Intake responses in GREEN below. Thanks! - Chris

INTAKE COMMENTS CST	Reviewer	
	Email	
	Status	
	Intake #

B. EAST ELEV.
 1/4" = 1'-0"

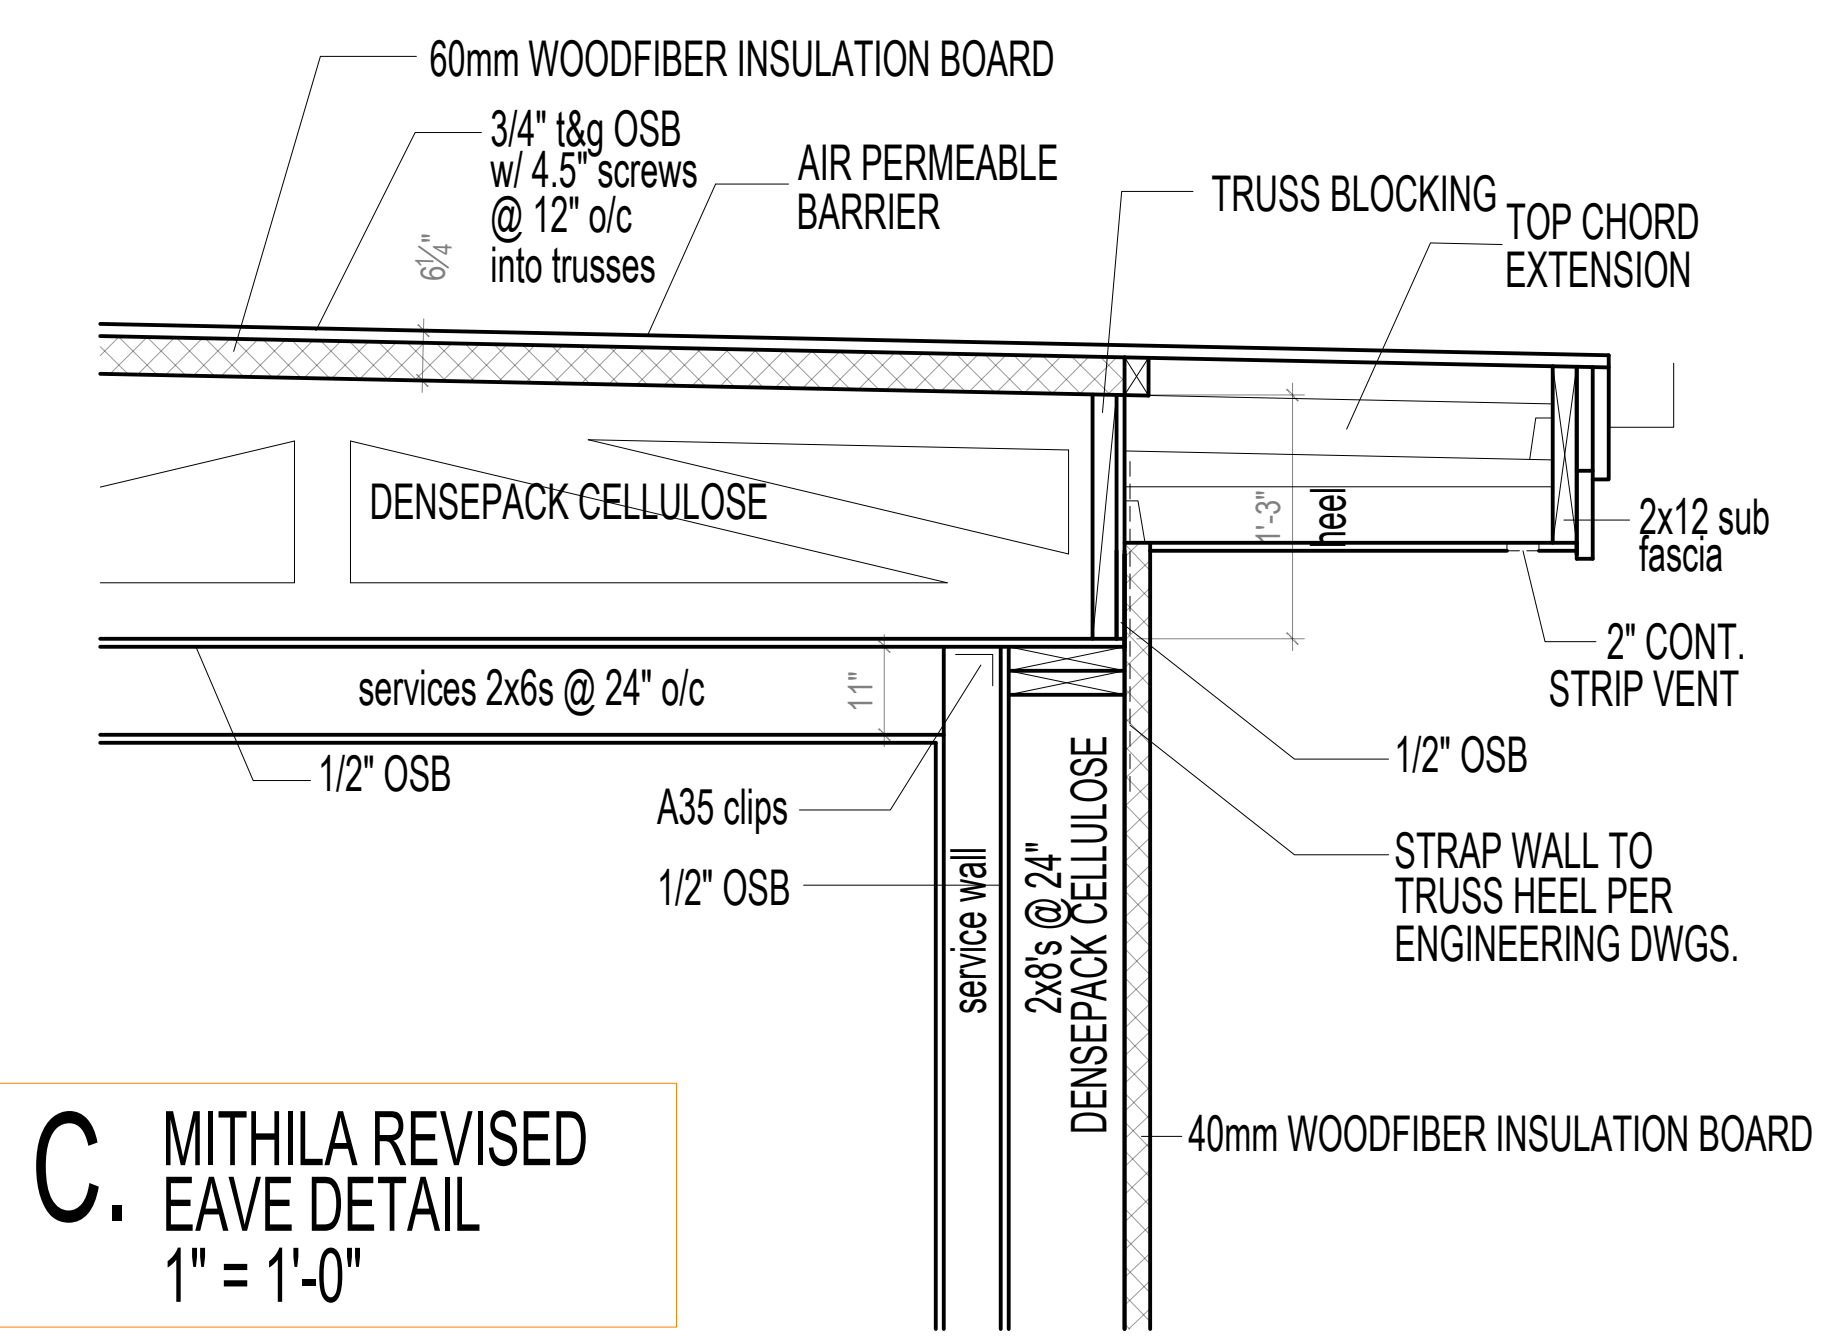
<input type="checkbox"/>	Indicate easements	
<input type="checkbox"/>	<input type="checkbox"/> Utility	<input type="checkbox"/> Ingress/Egress <input type="checkbox"/> Other
<input type="checkbox"/>	Elevation Drawings clean up east building elevation	
<input type="checkbox"/>	Indicate buildings and proposed height	
<input type="checkbox"/>	Indicate existing grade & finished grade	
<input type="checkbox"/>	Indicate Average Building Elevations (ABE) on all elevation drawings with ABE calculations	
<input type="checkbox"/>	Indicate maximum downhill building façade and height max downhill facade height is from existing or finished grade to the top plate of the upper story	
<input type="checkbox"/>	Height of appurtenances above max height	
<input type="checkbox"/>	Indicate allowable building height on all elevation drawings	
<input type="checkbox"/>	Provide calculations for any basement areas being excluded from allowable gross floor area

East elevation updated.
